CITY OF ALBUQUERQUE

**Re: Vista Oakland Subdivision, Grading and Drainage Plan
Engineer's Stamp Date 8-30-13 (C19D059)**

Based upon the information provided in your submittal received 8-30-13, the above referenced plan is approved for Preliminary Plat action by the DRB with the following comment as discussed 10-4-13.

CITY OF ALBUQUERQUE  
PUBLIC WORKS DEPARTMENT  
ENGINEERING DEVELOPMENT GROUP  
**VISTA OAKLAND SUBDIVISION**  
BEING A REPLAT OF LOT 1, BLOCK 3, UNIT 3, TRACT 2, NAA  
GRADING & DRAINAGE PLAN

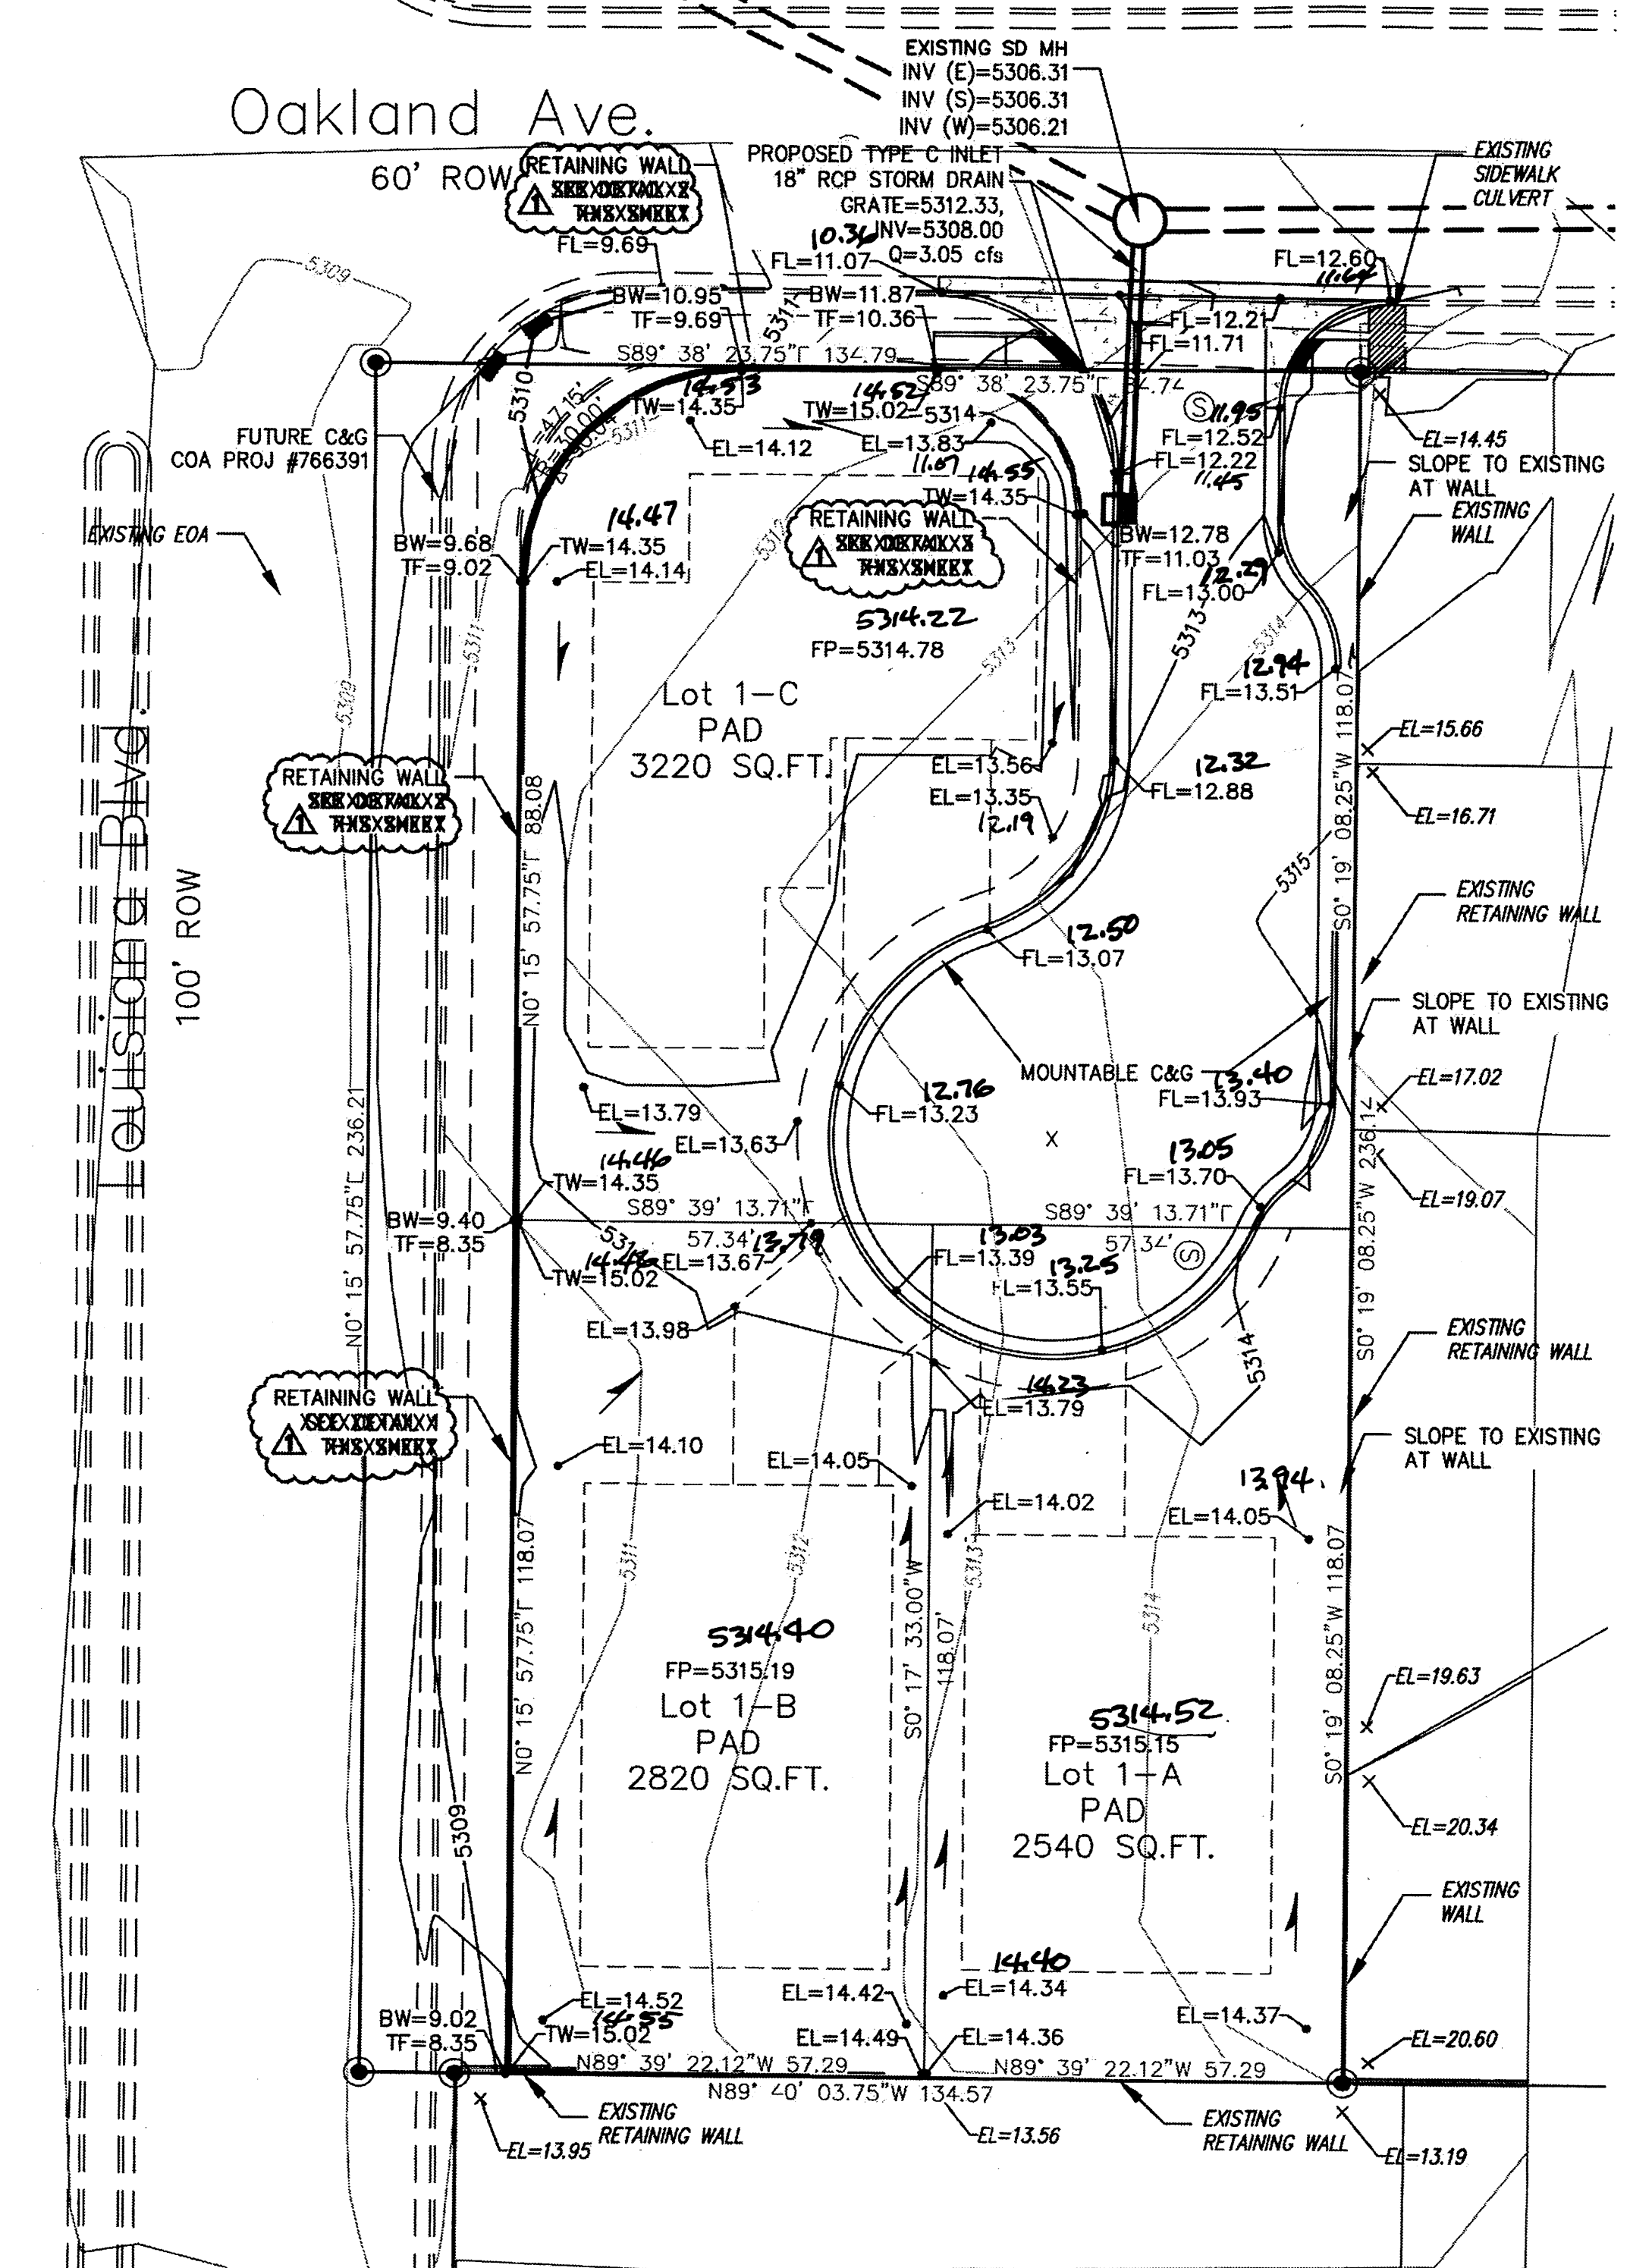
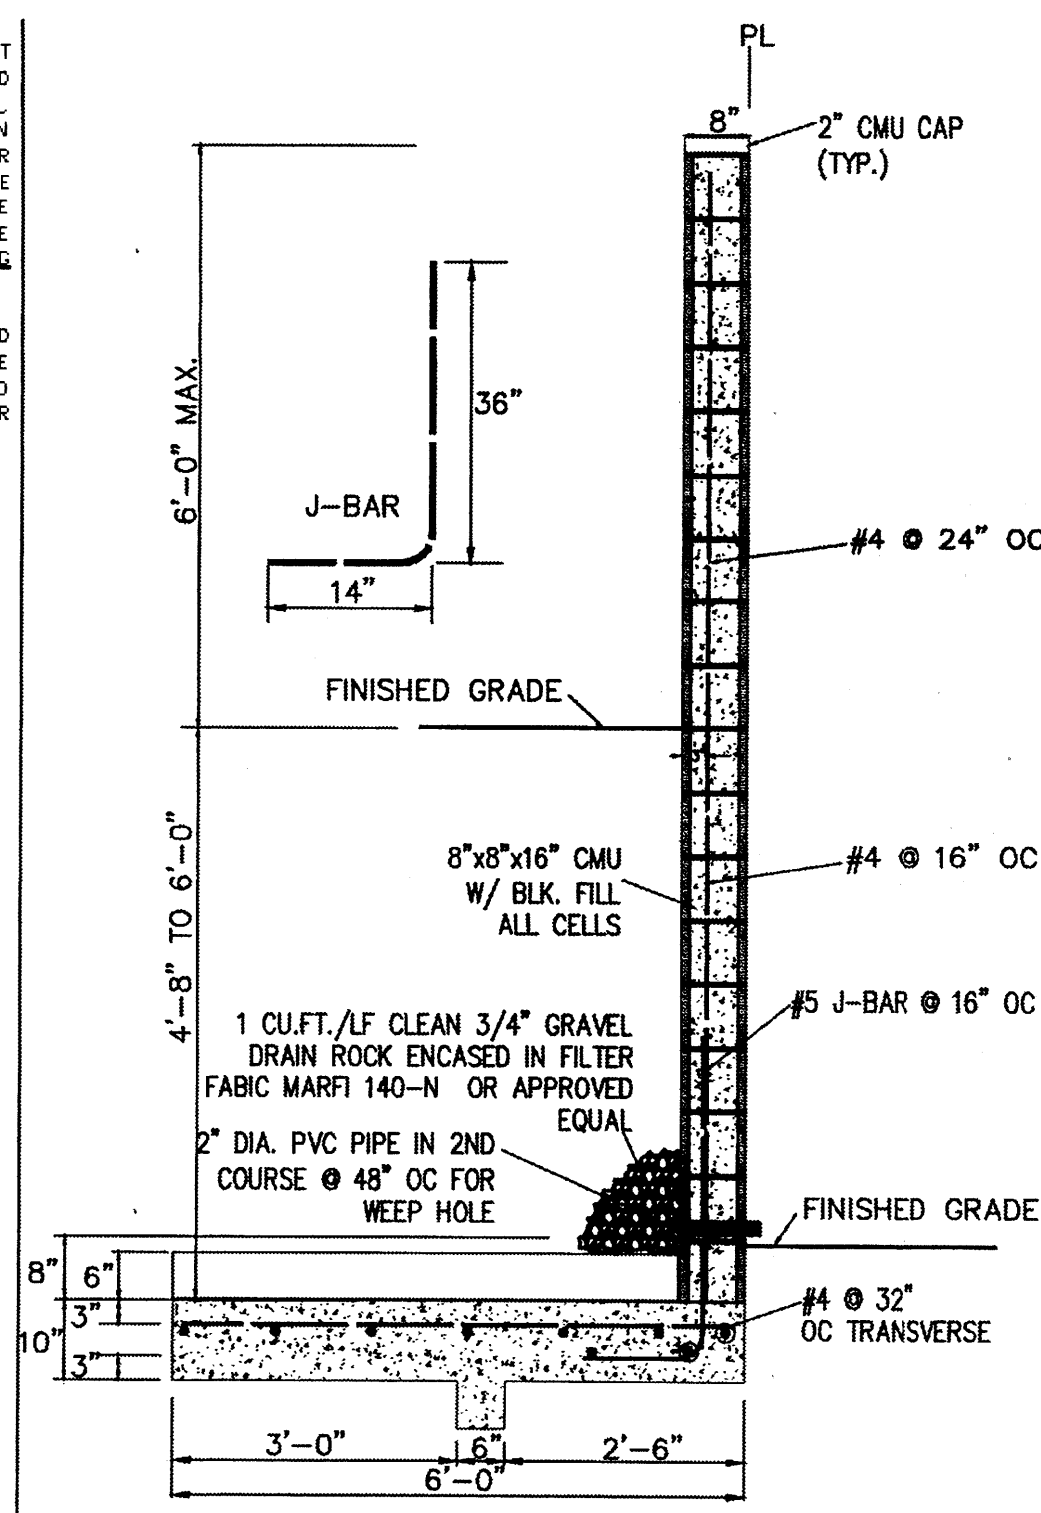
1. The curb along the eastern side of the street should be standard curb and gutter and depressed standard curb and gutter. Depressed standard and standard curb and gutter will help since access is not required along the eastern curb line and the taller curb will help prevent sediment from entering the street and storm drain as well as help to not disturb the footer of the existing wall.

2. The transition from mountable to depressed standard curb and gutter can occur within Lot 1-A.
